495 Forest Ave - Alta Vista LLC

I've started review of the application for the above address, to create a wholesale distribution center.

REAR BUILDING ELEVATION

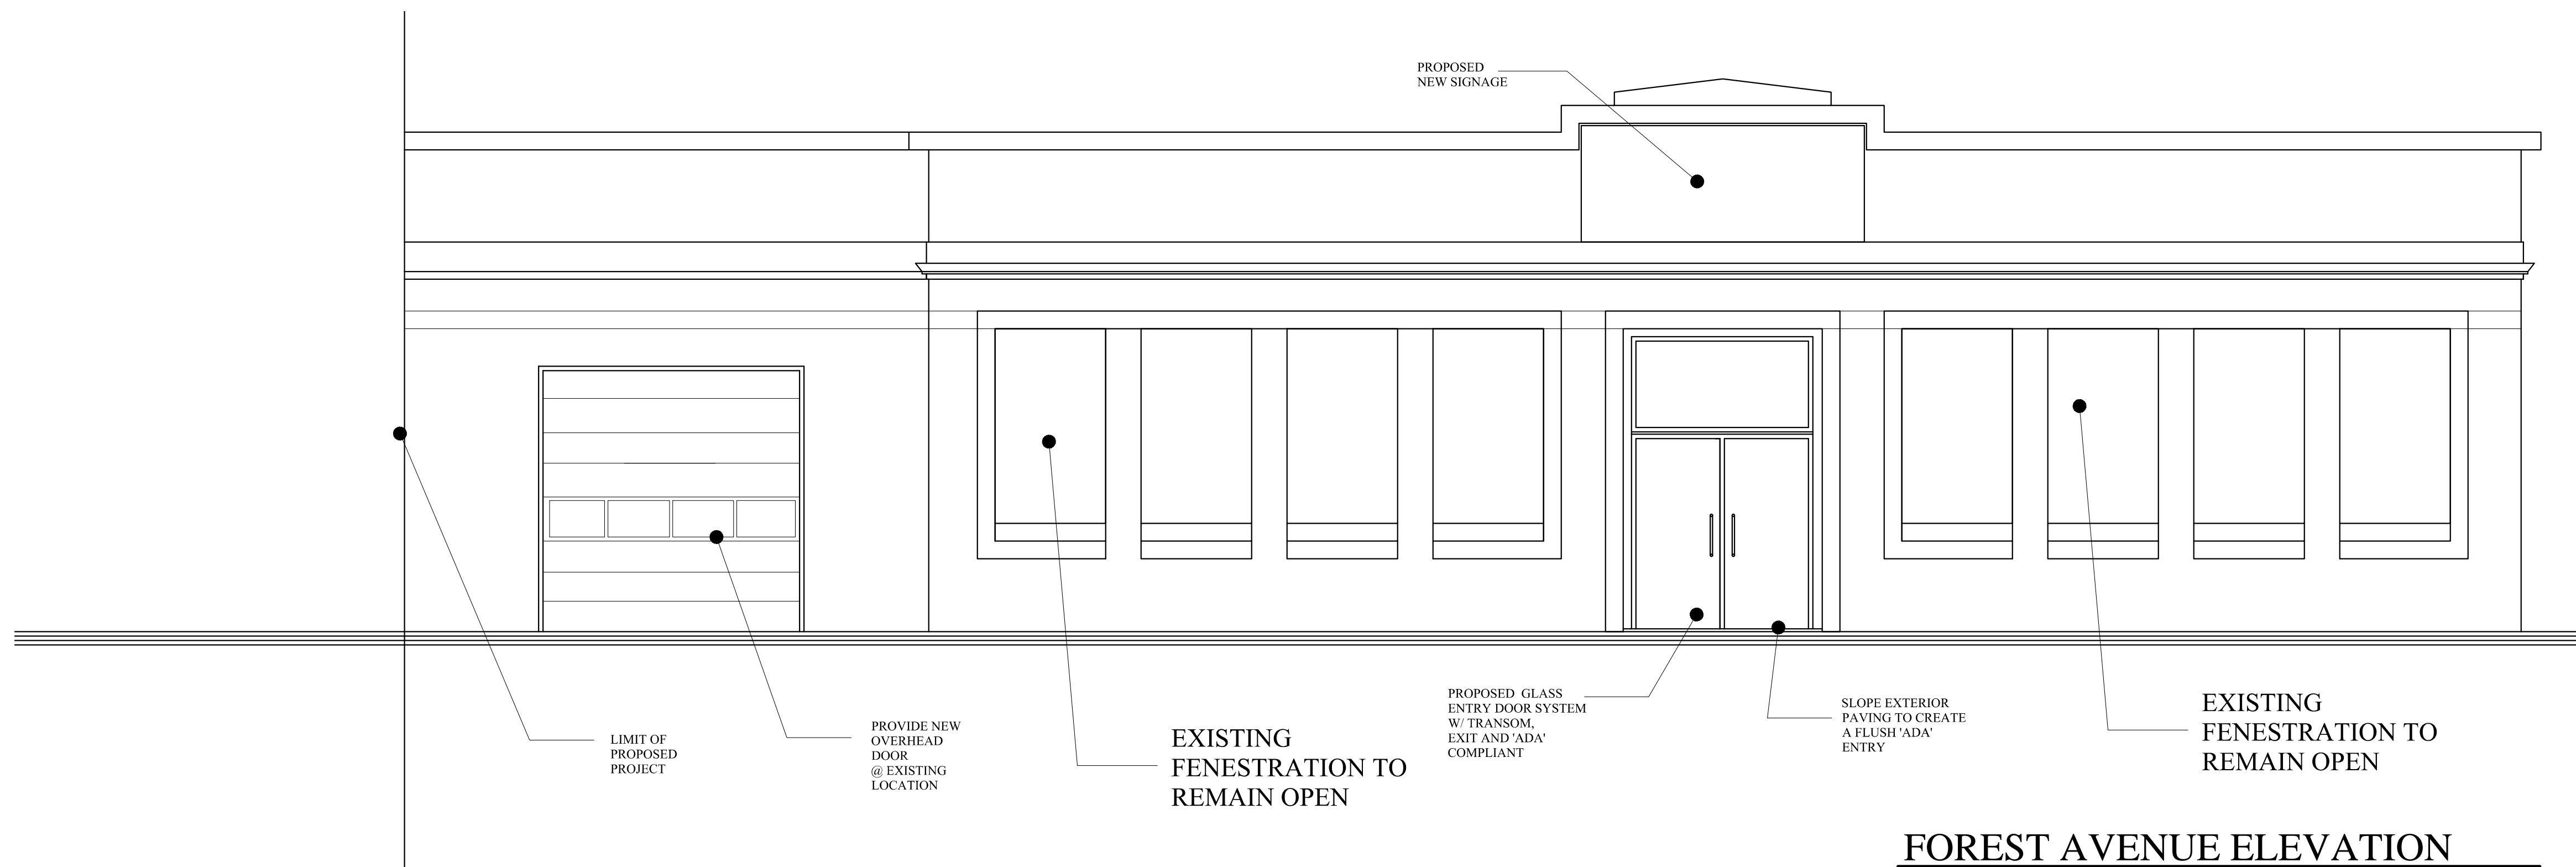
Also, she suggested that we find out if any new lighting in the rear of the building is proposed, and if so, that you send us specs for what will be installed. Any new lighting would have to meet full cut-off requirements so that there is no glare created for the neighboring residential building.

Item 3: we are proposing adding one entry door light fixture. It is small in scale and simple in detail, so we think it will be of little to no impact on the alleyway.

There is currently a more typical 'wall pack' existing above the overhead door. It is proposed this fixture remains.
